CITY OF ALBUQUERQUE PUBLIC WORKS DEPARTMENT	
TITLE: ANDERSON HEIGHTS - UNIT 4 GRADING & DRAINAGE PLAN	
DESIGN REVIEW COMMITTEE	CITY ENGINEER APPROVAL
LAST DESIGN UPDATE	MO./DAY/YR.
CITY PROJECT NO.	ZONE MAP NO.
SHEET 3 OF 4

**Re: Anderson Heights Unit 4 Grading and Drainage Plan
Revised Engineers stamp date 4-1-15 (N08 / D006F)
With revisions dates 4-22-15 (sht 3) and 4-14-15 (sht 4)**

RE: **Anderson Height Unit 4 (File: N08D006F)**
Drainage Report, Engineer's Stamp Date 2-12-2015
Grading & Drainage Plan Engineer's Stamp Date 5-1-2015

NOTES

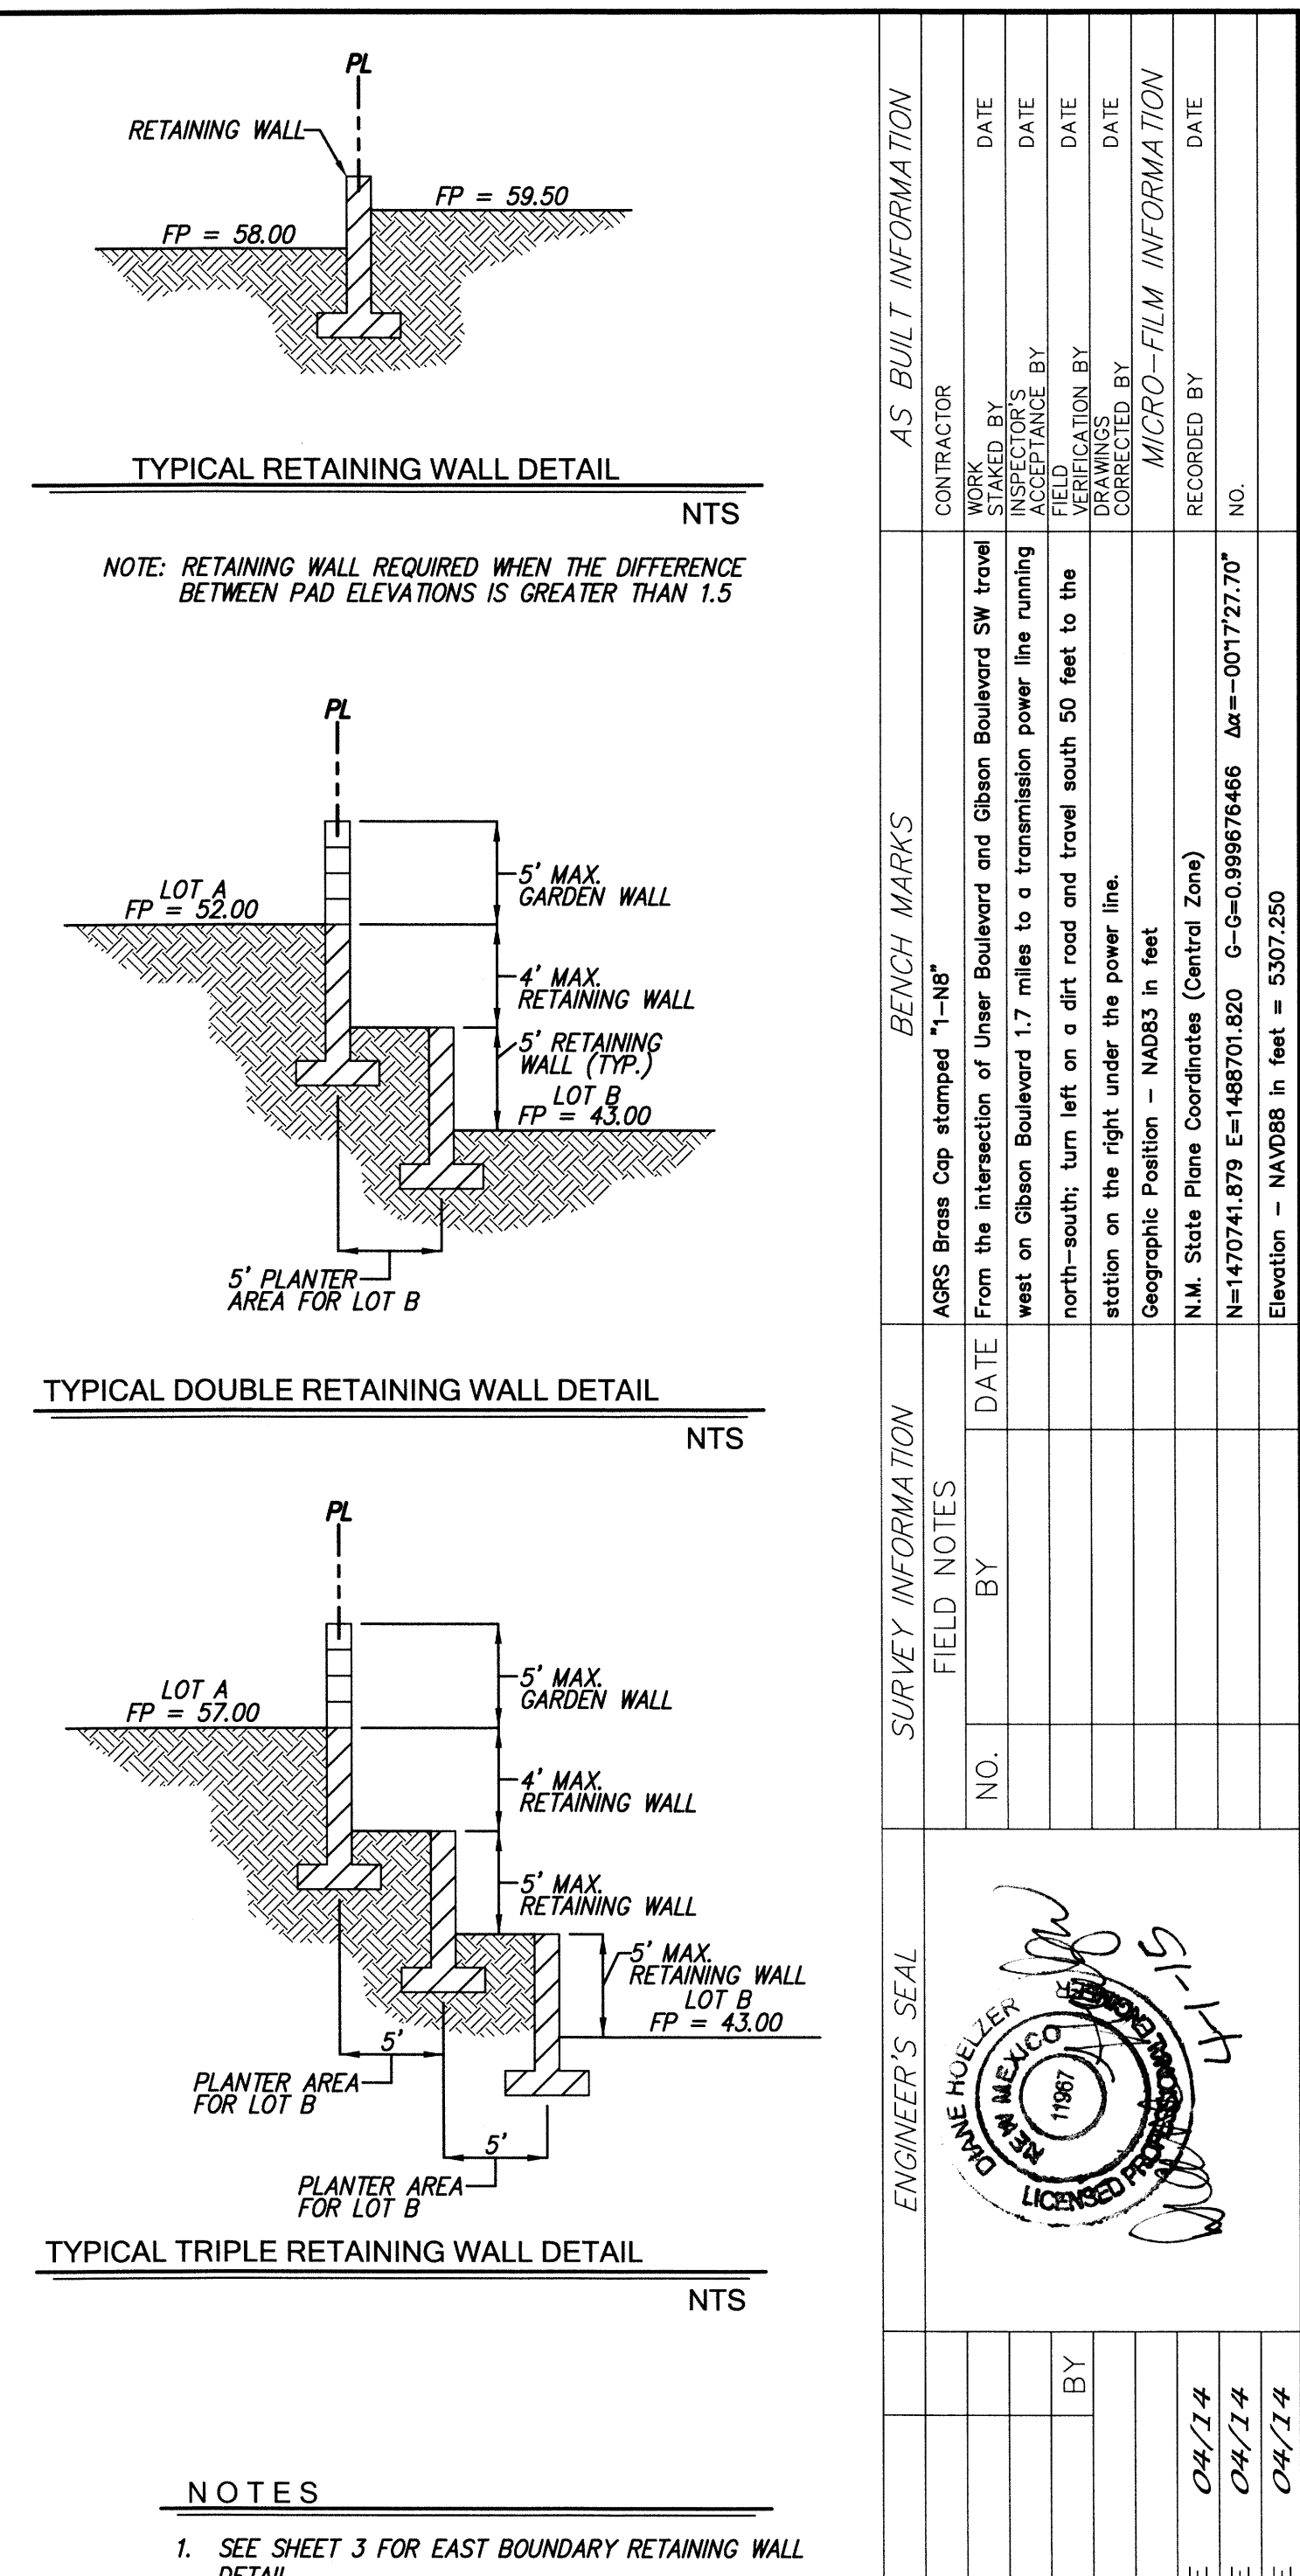
In response to comments received at DRB from Open Space and from conversations regarding the retaining walls along the east property boundary:

1. The Memorial Park was revised to add additional detail to the plan. The concept is unchanged just more detail.
2. The grades along the east property line were revisited. I have lowered the grades in Jacob Bay Court as much as possible while still maintaining minimum required cover over the storm drain. I have graded the backyards so that the grades are equal to or below the TWRW (top of west retaining wall).
3. The grades in Dundee Street remain unchanged. There is already minimum cover over the storm drain in this street. Consequently, the back yard grades, along Dundee Street, are higher than the TWRW. I have indicated proposed retaining walls along this area as shown on the revised plan. The maximum additional retainage is 2.0 feet.
